Re: Proposed development of a resource recovery centre (including waste-to-energy facility)
in Ringaskiddy, County Cork.

From: Dr. Bettie Higgs, Chairperson Cork Geological Association,
Beechwood House
St. Philomena's Road
Crosshaven
Co. Cork

Planning application: PA04.318802 Applicant: Indaver Ireland

This submission highlights some key gaps, deficiencies and inconsistencies in the Indaver 2025 Environmental Impact Statement (EIS). While the documentation is extensive, the underlying evidence base is inconsistent between sections, sometimes contradictory, and in places overly reliant on broad assumptions, leading to speculative statements.

Figure 13 Projected Cliff Top Retreat Lines (including updated Assessment, see Appendix I) Based on the 2025 Topographic Baseline for 30-Year (2055) and 40-Year (2065) Timeframes

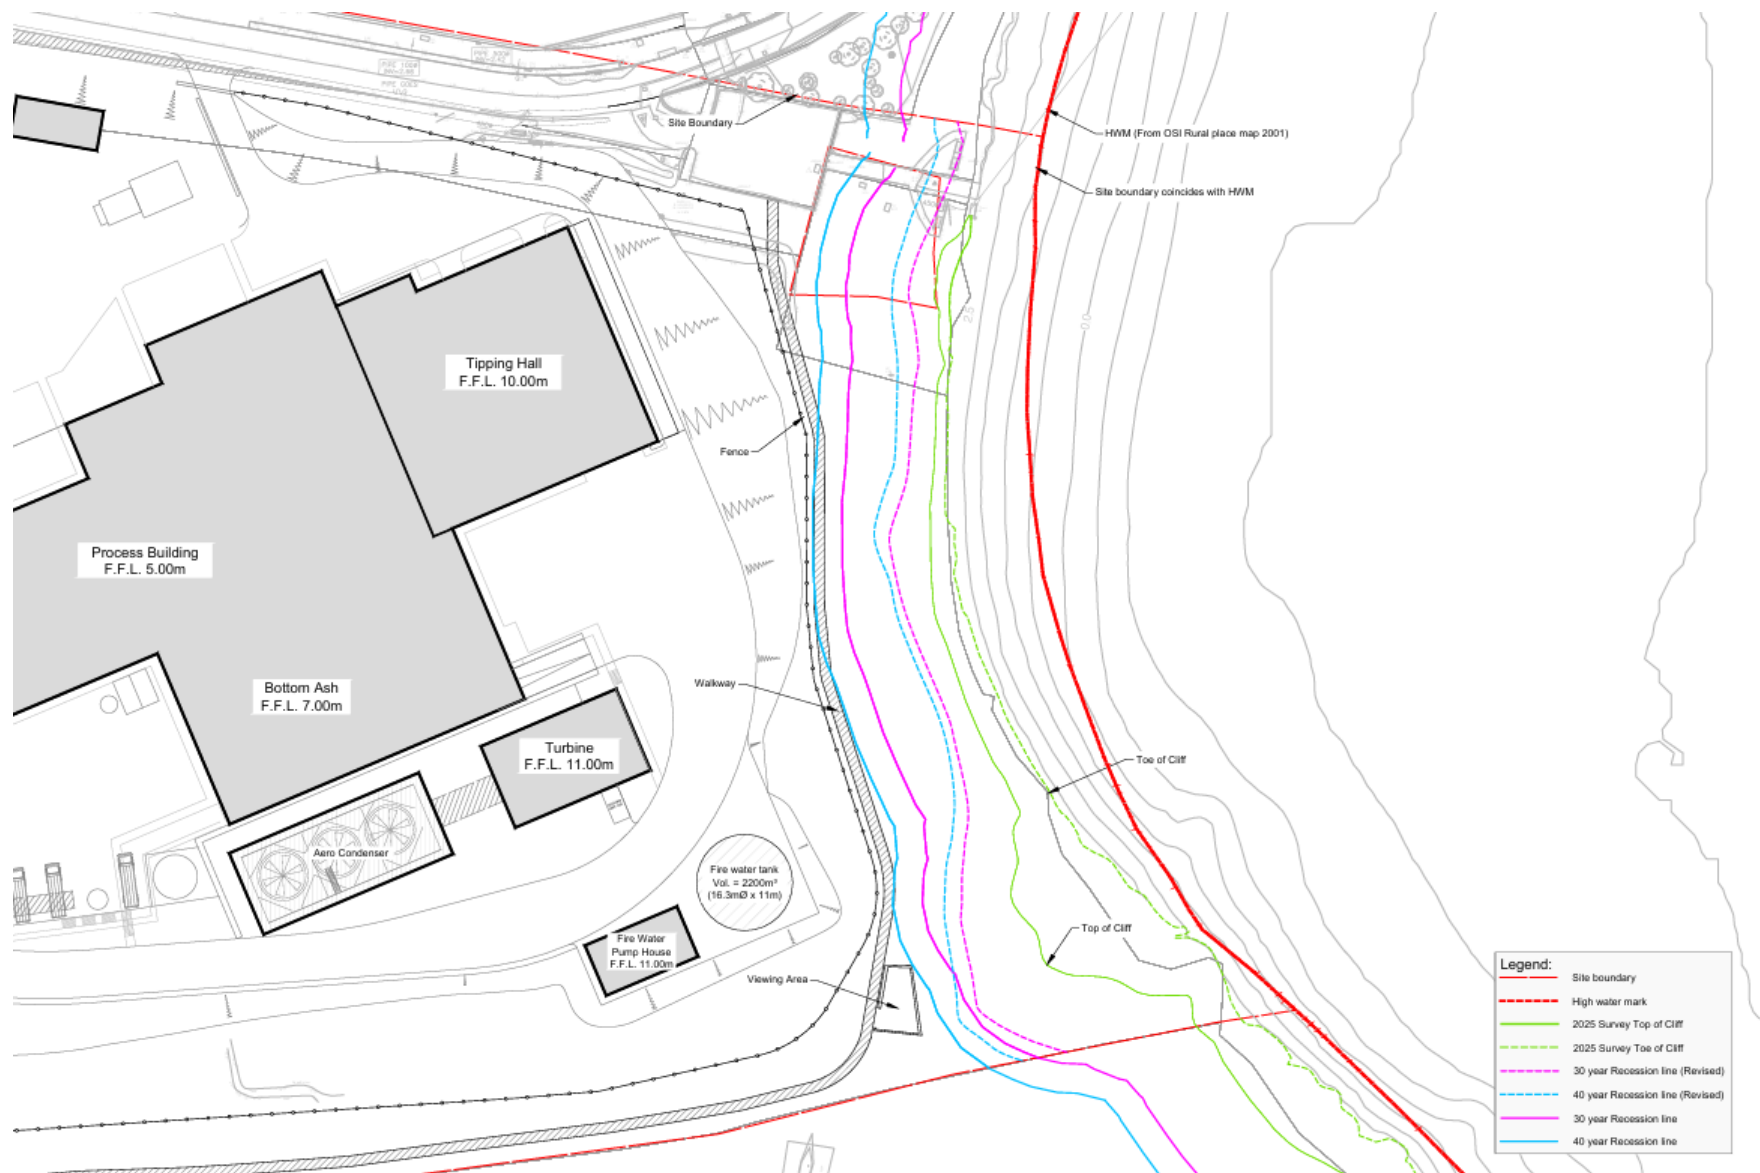
The Indaver EIS omits addressing how increased erosion of vulnerable cliffs immediately to the south of the site will be prevented.

Indaver states that there will be no negative impact on adjoining areas, as only shingle nourishment is proposed. Dynamic modelling has not been carried out to substantiate this claim.

Any imported shingle or fixed rock armour at the Indaver site, no matter what material, will upset the natural erosional equilibrium. Rock or shingle will deflect wave energy to adjacent unprotected coastline. This increased erosion is a well-known phenomenon when coastal defence is implemented. Rock armour increases local turbulence and deflects wave energy, concentrating the erosion and causing undercutting at the unprotected adjacent cliffs. The adjacent cliffs are up to 15m in height and made of easily eroded glacial till (identified as the 'Ringaskiddy Drumlin' in publications). Increased erosion will reduce buttressing, encouraging increased local landslips.

Given the proximity of unconsolidated Quaternary cliffs immediately to the south, and the absence of quantified modelling in the EIS there is insufficient evidence that a coastal defence installation would not accelerate erosion of the southern cliffs.

Meteorologists and climate scientists are united in warning of increased storm frequency and severity. Since this is already an actively eroding site, Indaver do not state what their future strategy will be with respect to rock armour. The EIS adopts a uniform linear rate of erosion of 0.5m/yr (based on smoothed data) yet acknowledges episodic failure of 12m in a single event. A linear retreat assumption for the next 30 years is unjustified when erosion is influenced by extreme storm events and climate change. The Indaver EIS has no measurable thresholds that would trigger enhanced mitigation.

The EIS significantly underestimates the probability of rapid cliff failure south of the Indaver site. Statements like "no effects are expected within 30 years" are speculative only and uncover a credibility gap.

Beach Nourishment Solution

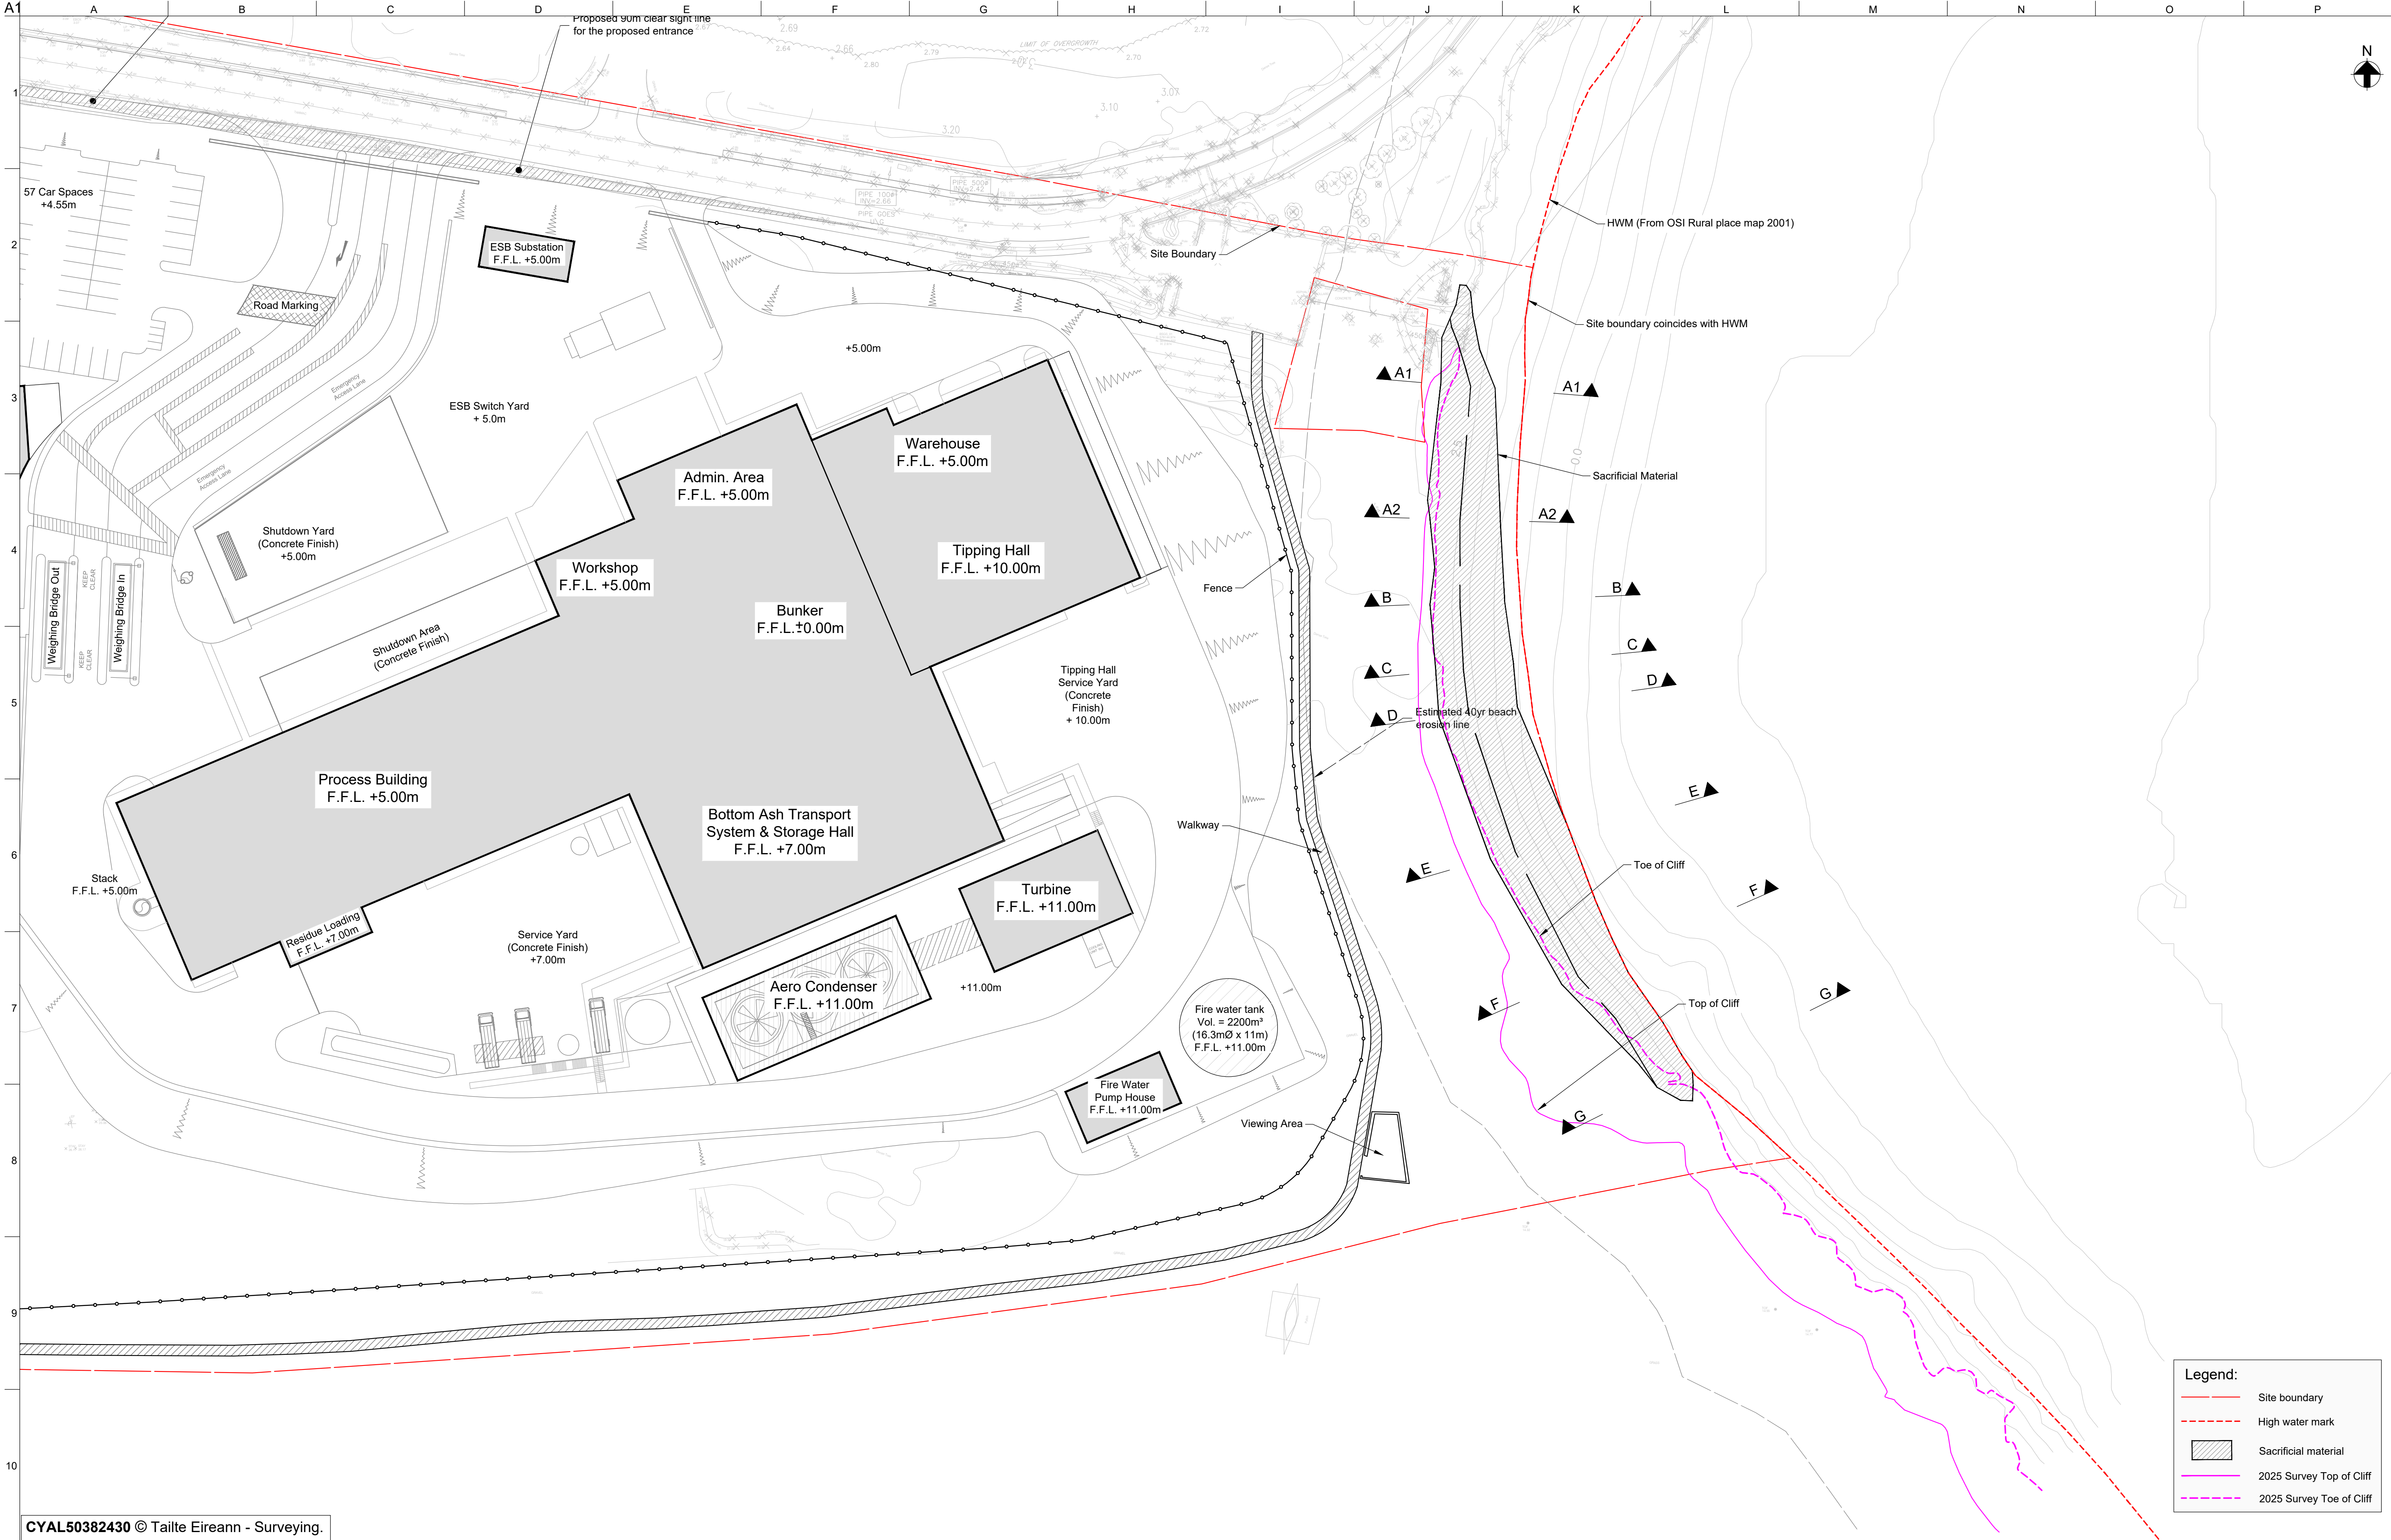
The Indaver EIS omits the physical properties of the shingle proposed as beach nourishment and coastal erosion barrier. There is no geomorphological baseline study, or detailed shingle beach management plan that prevents loss of habitats, and damage or fragmentation of heritage.

‘Shingle’ is an informal term and can include a wide variation in size, shape, texture and composition of the clasts. These clast characteristics have a significant influence on the clast movement when exposed to wave and current action. The current EIS uses the informal non-committal term ‘shingle’ and avoids being specific.

The Indaver EIS references Pye and Blott (2018) without explaining how they would implement the authors’ findings. The authors state best practice is to have shingle as near as possible to the existing beach shingle. The existing beach material is wave-reworked glacial till which has evolved over the past 10,000 years. There is no ready source/supply of such material in Ireland to make a 1,150m³ barrier. In the previous EIS (2016) Indaver named O’Neill’s Quarry as the source of ‘beach nourishment’. It was pointed out that the size, shape and composition of the gravel in O’Neill’s Quarry is very different to Gobby Beach and the Golden rock County Heritage Site, as it formed by a very different process. Using such material would cause irreparable damage to the heritage site. The Indaver EIS avoids addressing this point.

Indaver states that coastal protection measures (beach nourishment) will prevent further erosion, and assumes success in order to classify the risk as negligible. This is a circular argument. Mitigation using 'beach nourishment' has not been proven or modelled, and so the impact assessment is speculative at best.
